Our Reference: 12301/PREC 1/1

**Kings Forest Service Station & Food Outlets Land and Environment Court Appeal
Response to Key Issues contained in DoPE letter dated 15 November 2016**

On behalf of the proponents (Project 28 Pty Ltd) we provide the following response to DoPE's letter dated 15 November 2016 in regards to civil engineering matters:

DRAWING NUMBER	AMEND
12301-SK-061	A

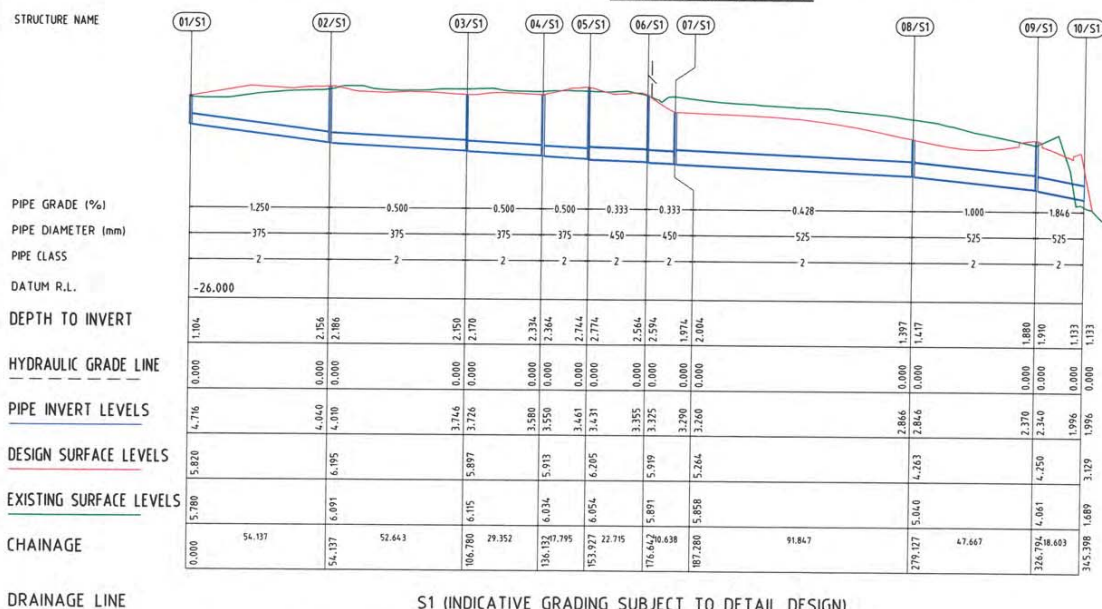
- a. *Water: The stormwater engineering drawings should show geometry of surfaces and the drainage system.*

Please find attached Mortons-Urban Solutions drawing number 12301-SK060A (Rev C) and 12301-SK061 (Rev A) showing preliminary earthworks grading of the site and preliminary stormwater infrastructure to cater for surface runoff. These drawings have been updated to incorporate bio retention systems for stormwater quality in accordance with the stormwater quality management plan submitted by others.

DESIGNED RB	DRAWN RB	
APPROVED		DATE 16-12-1
DRAWING NUMBER		AMEN
12301-SK-060B		A

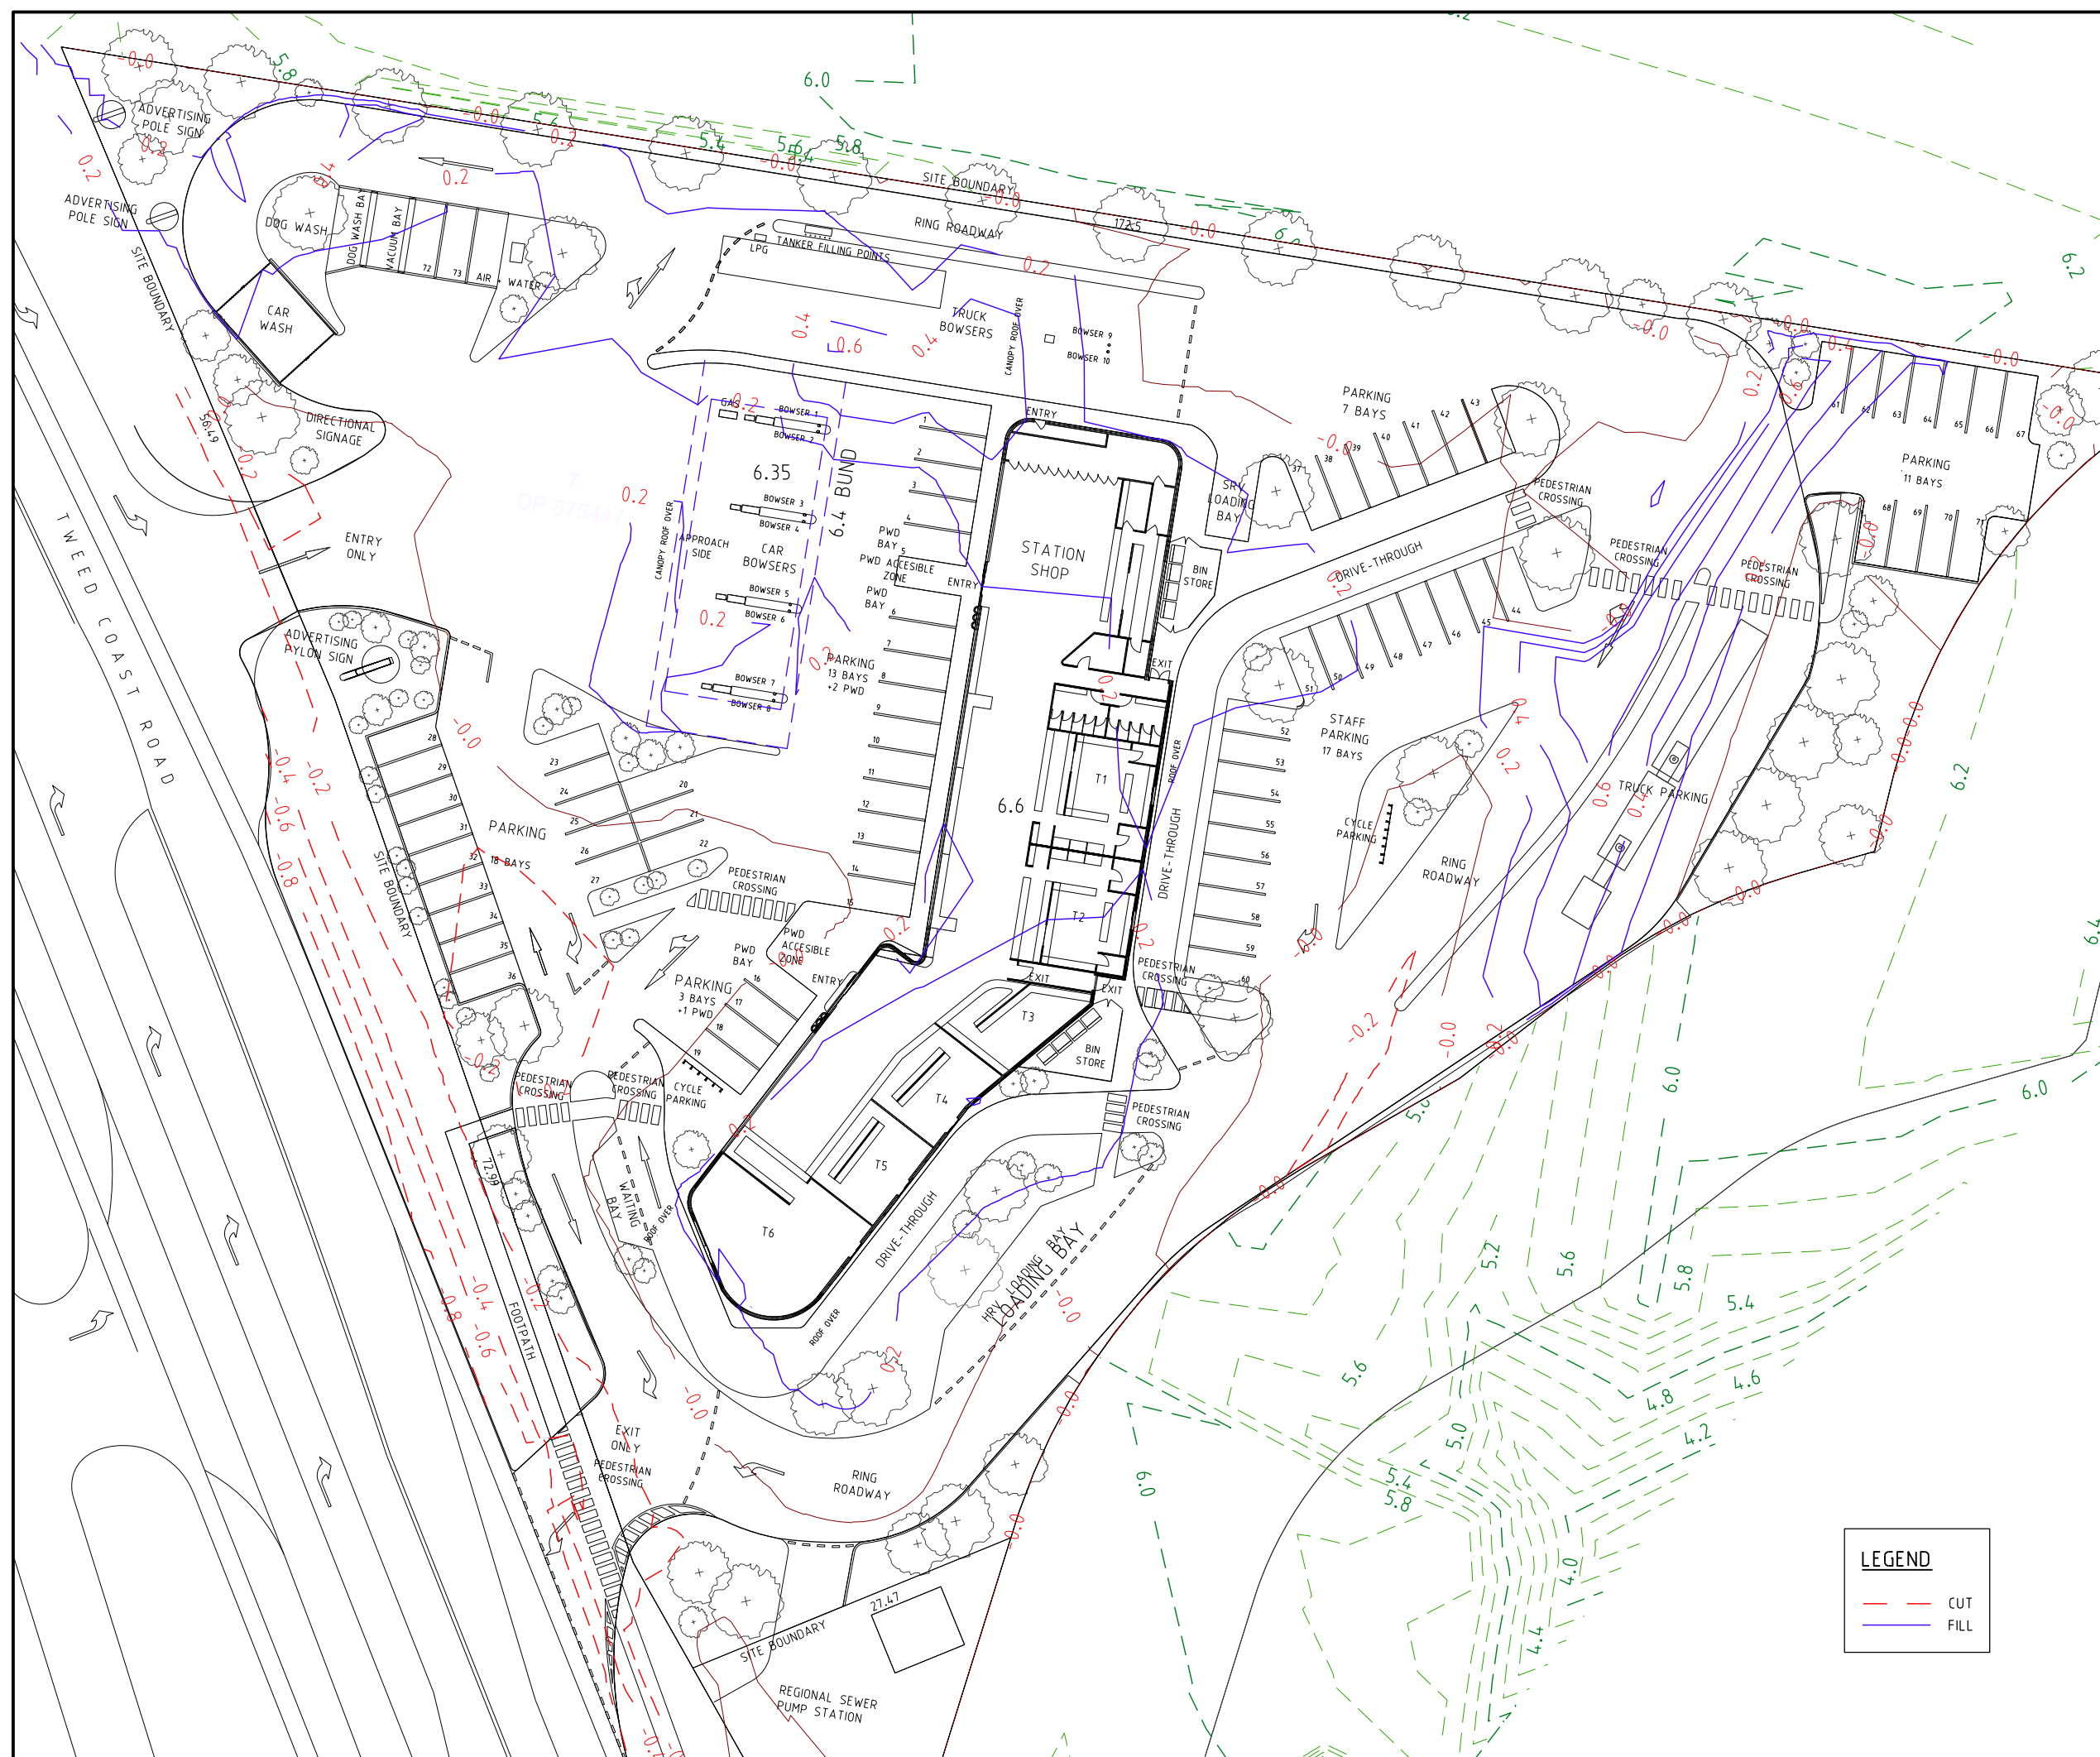
- b. *An infrastructure Plan showing sewer and water services should be provided.*

We note that the stormwater drainage is to pick up surface flows and roof water and be conveyed to the bio retention ponds prior to discharging into the stormwater infrastructure along Kings Forest Parkway. The fuel dispensing area runoff will not be conveyed to the stormwater reticulation system as this area is to be bunded and drain to a sump collection system. This is not shown on the attached drawings as detailed design of the bunding and sump will be completed as part of building hydraulics.

Please find attached Mortons-Urban Solutions Drawing number 12301-SK060A (amend C) showing sewer and water connections for the proposed service station and food outlet. The plan shows how the overall site is serviced; however, individual buildings will be designed by the building hydraulics engineer at the time of detailed design. As reported in Mortons-Urban Solutions original servicing report for the proposed development water and sewer infrastructure to the site is proposed by the following:

There is no current sewer infrastructure to service the proposed development. Sewerage from the Kings Forest Development will be pumped to a proposed Regional Pump Station 01 (SPS 4023 as previously allocated in Council's numbering system). This pump station is to be constructed by Project 28 Pty Ltd as part of Stage 1 of the development. The location of SPS 01 is shown on the attached drawings 12301-SK-060A (Rev C)
